Our ref: DOC19/608942  
Your Ref: MP05\_0142 MOD 2

**EES comments on Aldi Distribution Centre – Modification 2 – internal alterations and additions, extension of car park, landscaping and associated works – MP05\_0142 MOD 2**

**Subject: EES comments on Aldi Distribution centre – Modification 2 Internal alterations and additions, extension of car park, landscaping and associated works – MP05\_0142- Mod 2**

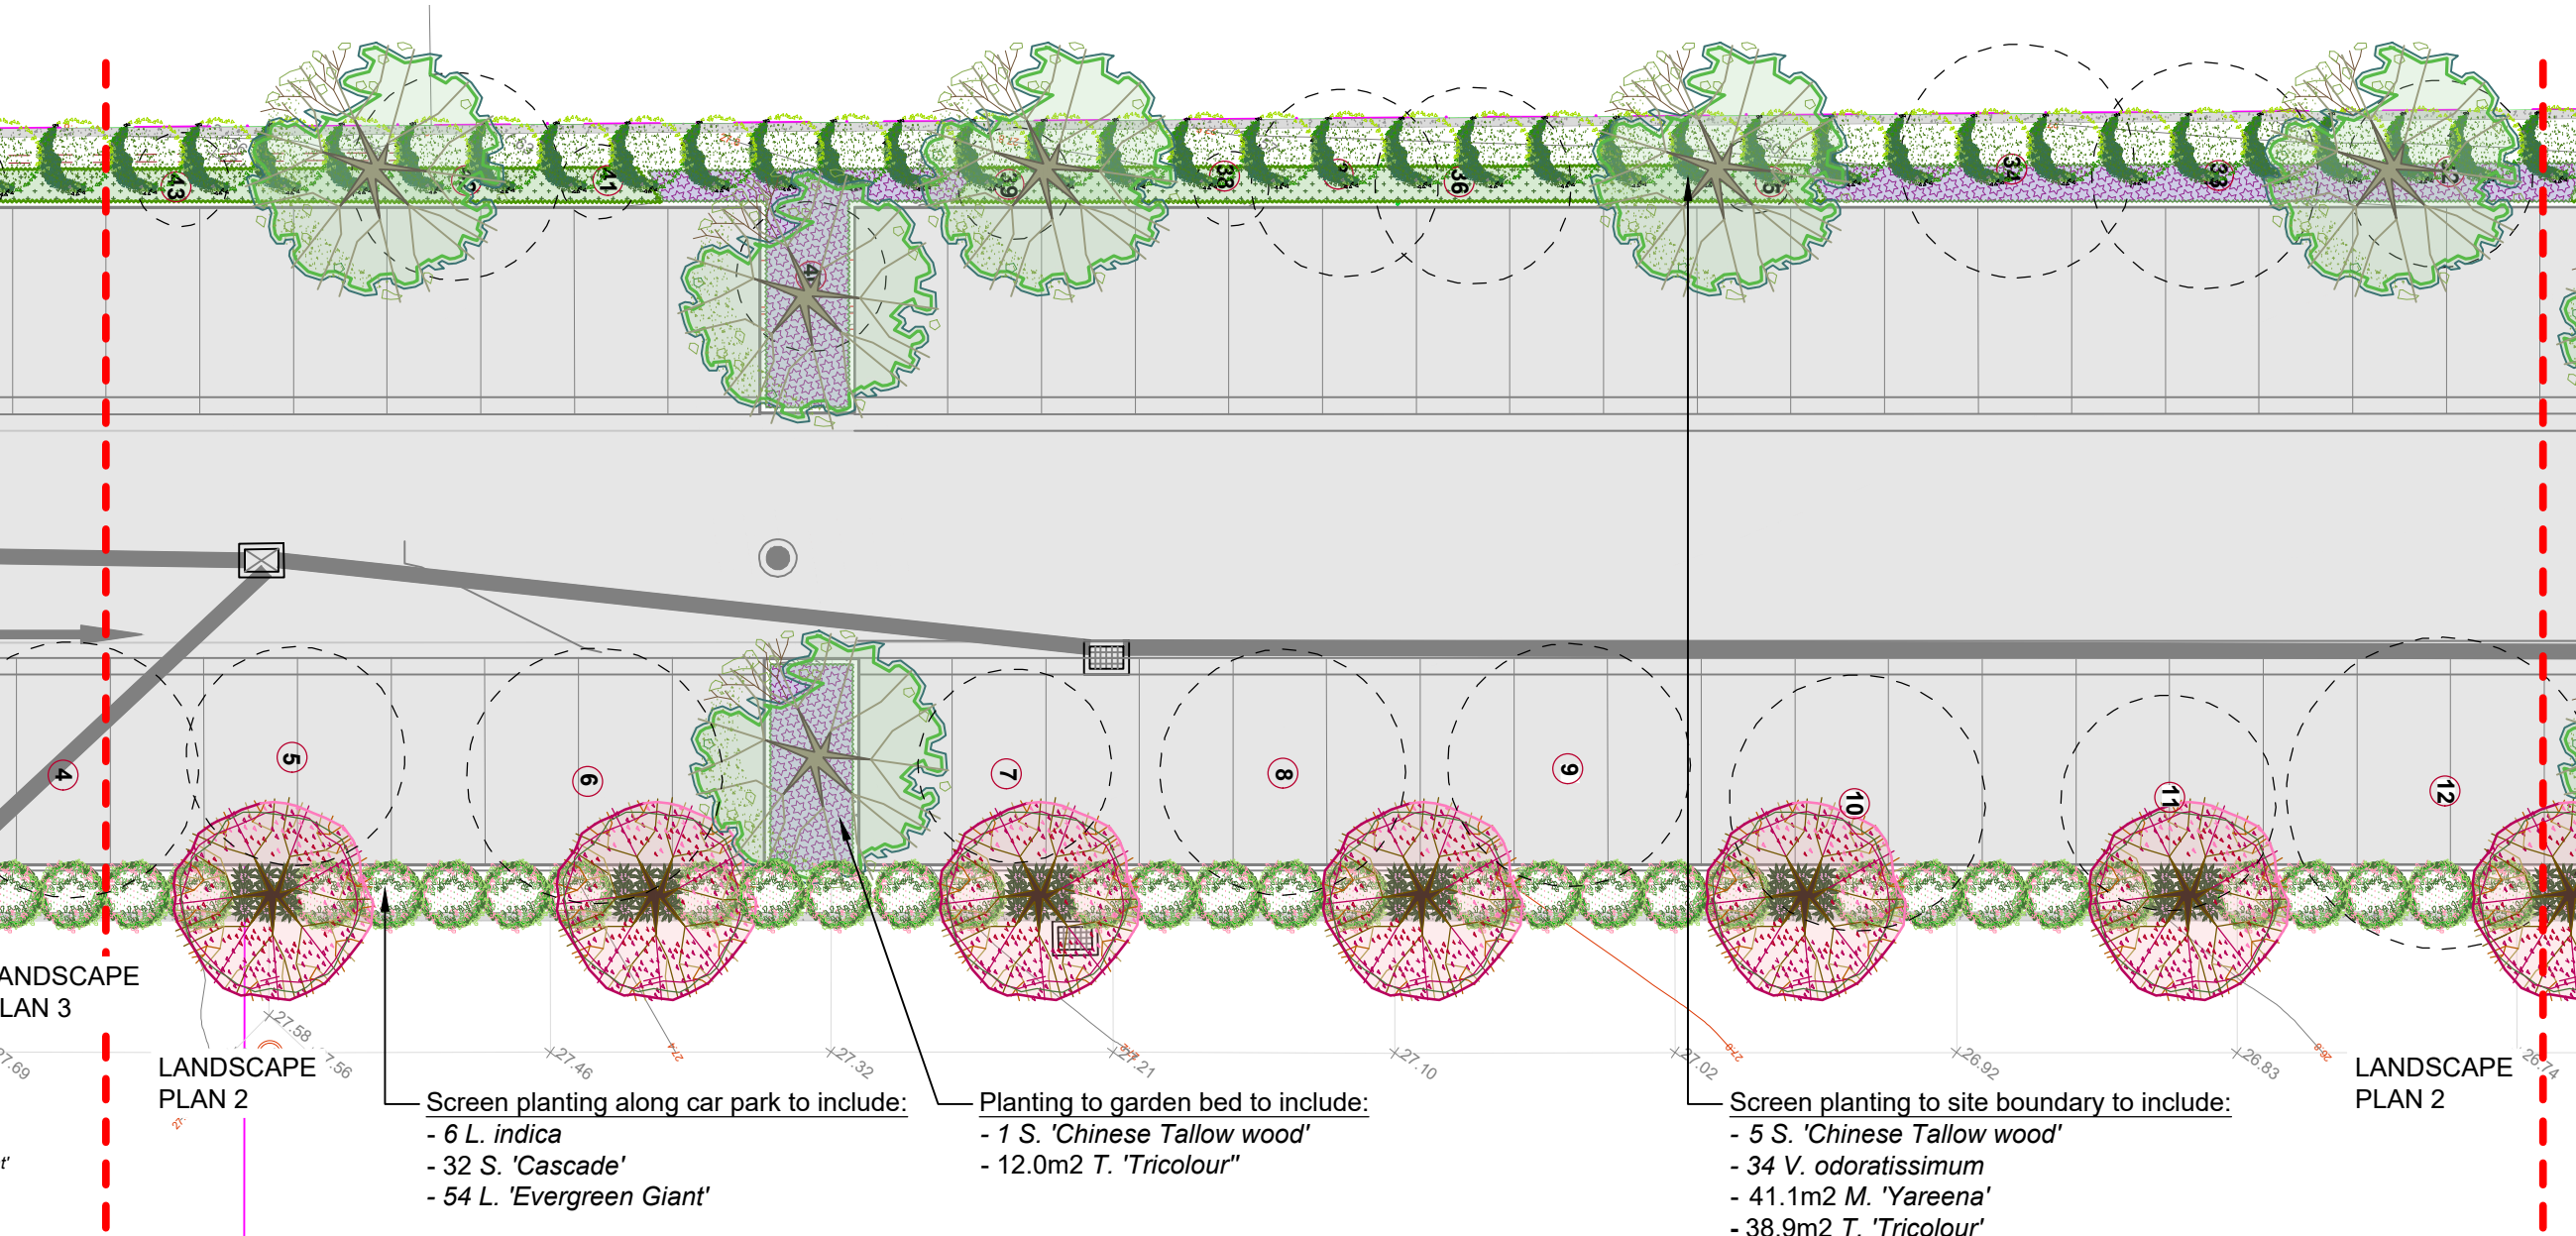
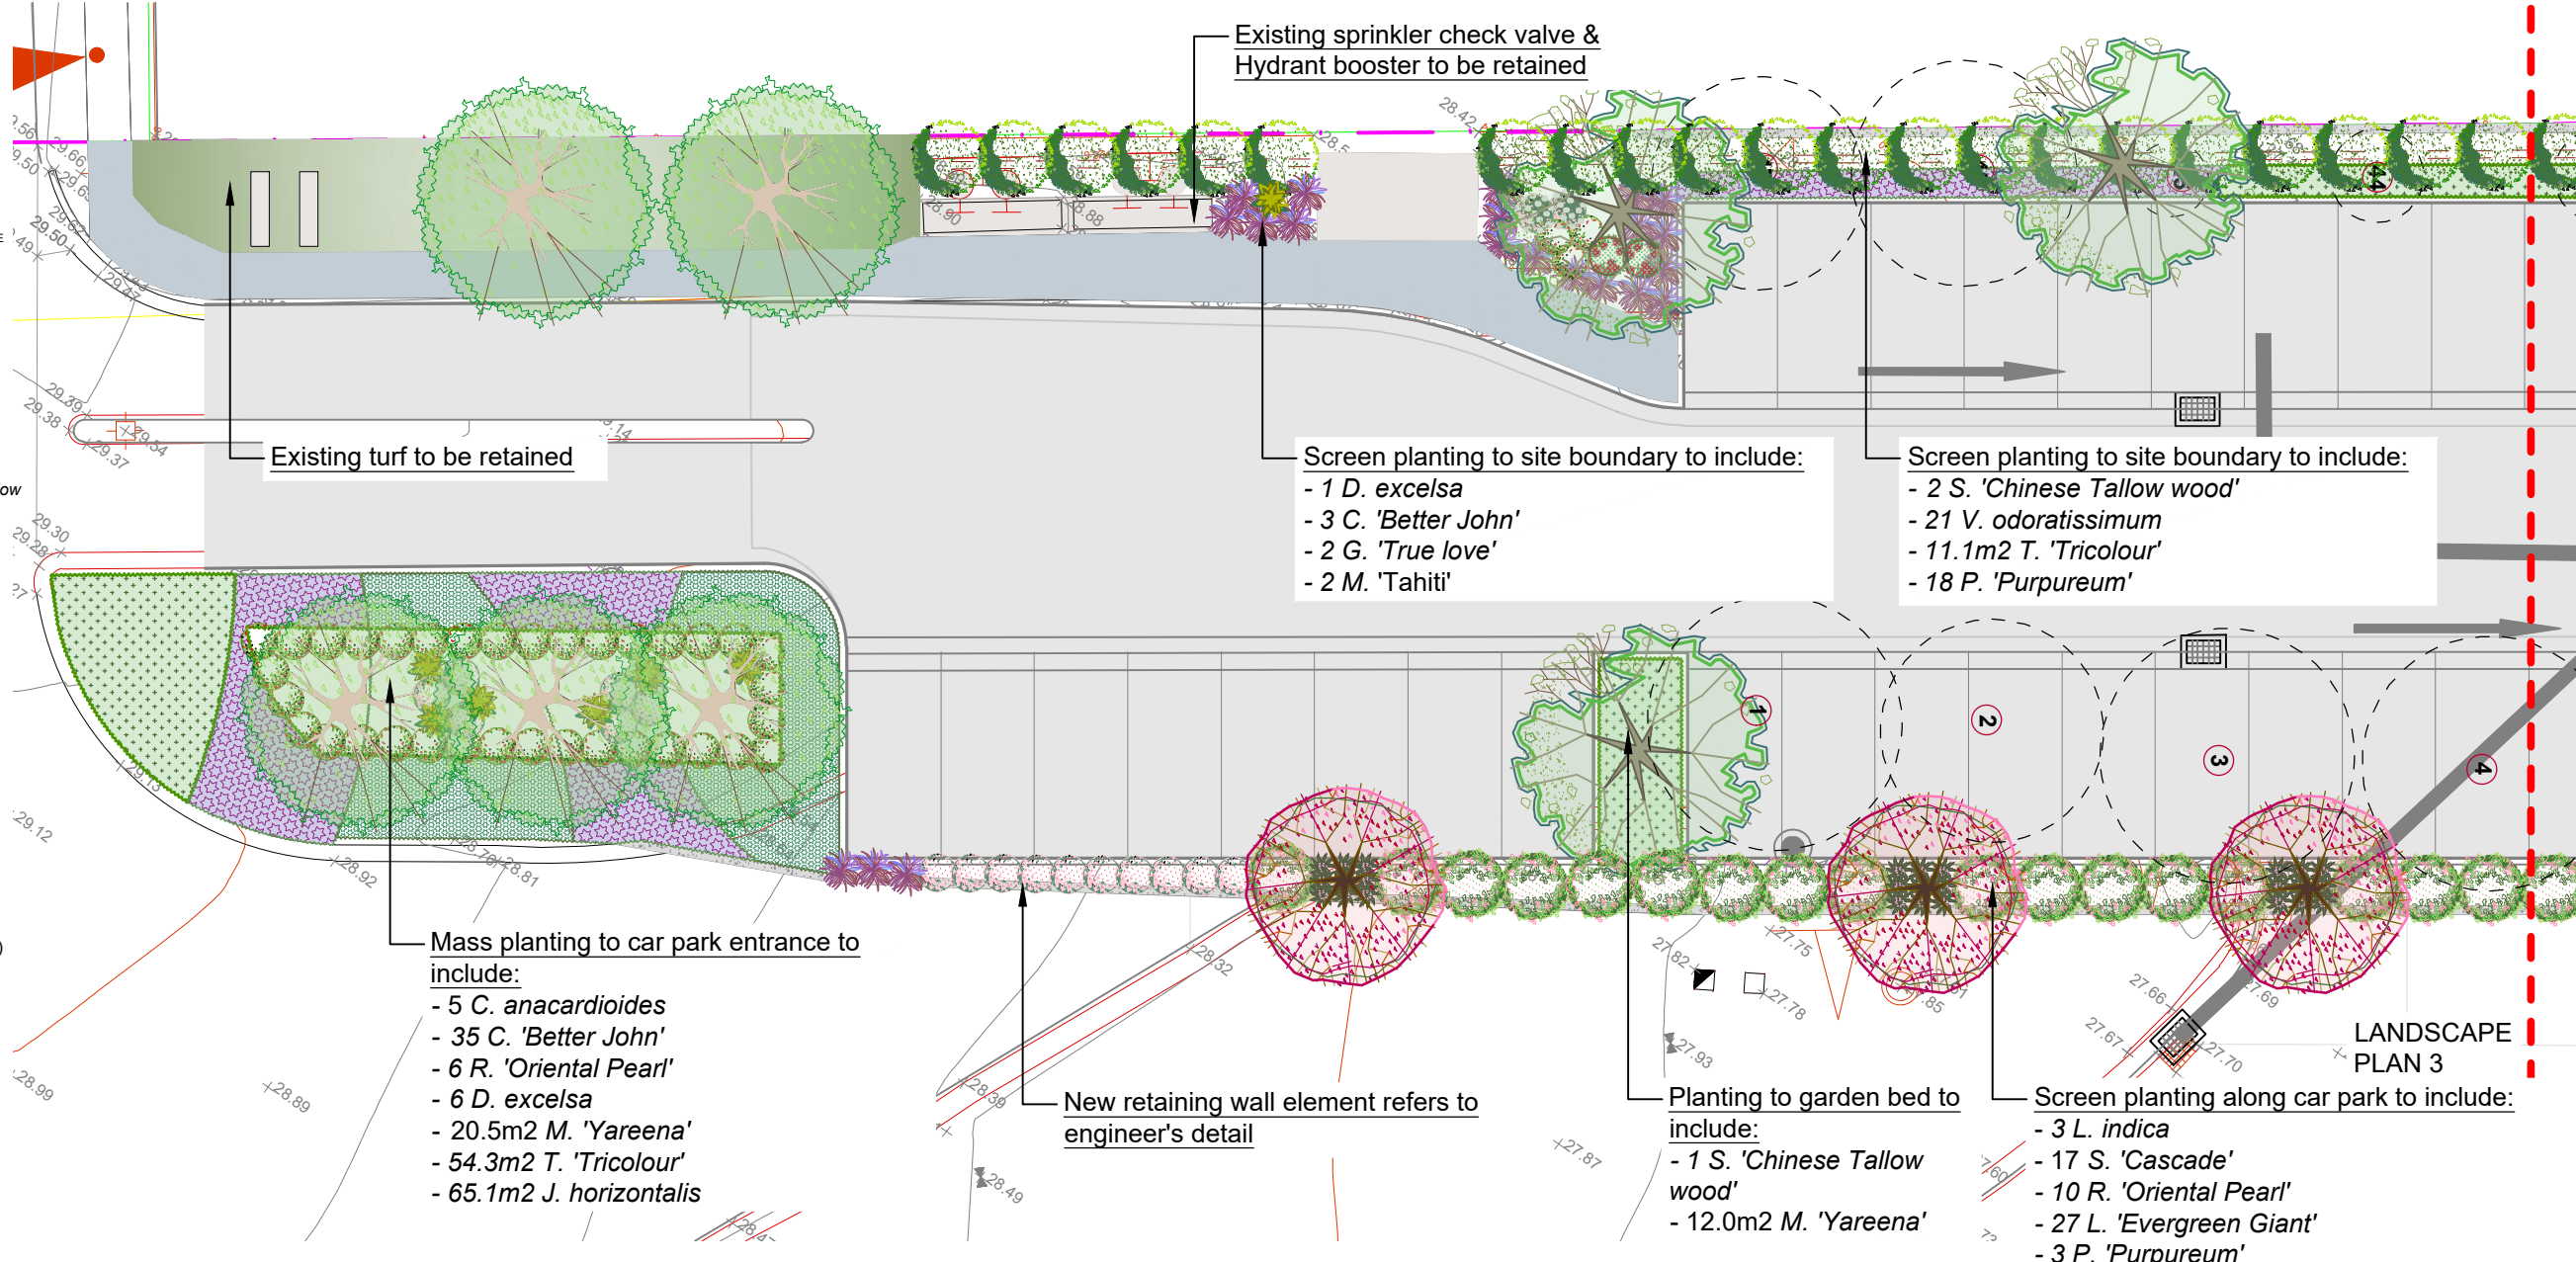
The Landscape Plans for MOD 2 propose to plant 16 Chinese tallow trees (*Sapium sebiferum*) on the site. Prior to approving the modification, it is recommended the Planning and Assessment Group considers information relating to the Chinese tallow tree available for example on the NSW Department of Primary Industries website – see NSW Weedwise link at: (<http://weeds.dpi.nsw.gov.au/Weeds/Details/38>).

If there is potential for Chinese tallow tree to spread from the site it is recommended it is removed from the Landscape Plans.

EES recommends the Landscape Plans are amended and the site landscaping uses a diversity of local native provenance trees, shrubs and groundcover species from STF plant species that once occurred on the site. The proponent should demonstrate that the plant species list comprises local provenance STF plant species.

The MOD 2 proposal, as noted above proposes to remove 51 trees from the site (see AIA, page 13) and only plant 36 replacement trees (see Landscape Plans 1-3). Of the trees to be removed 35 are semi-mature and 8 are mature trees. The loss of existing trees from the site and the many benefits that trees provide takes years for a juvenile tree to grow and replace.

- 1) The landscape plan shall use use a diversity of local native provenance trees, shrubs and groundcover species (rather than exotic species or non-local native species) from the Sandstone-Gravel Transition Forest vegetation community which once occurred on the site.

- 2) The landscape plan shall include details on a list of local provenance tree, shrub and groundcovers to be used in the landscaping, the quantity and location.

- 3) Trees removed from the site shall be replaced at a ratio greater than 1:1
- 4) The landscaping shall use advanced and established local native trees preferably with a plant container pot size of 100 litres, or greater to increase urban tree canopy cover.
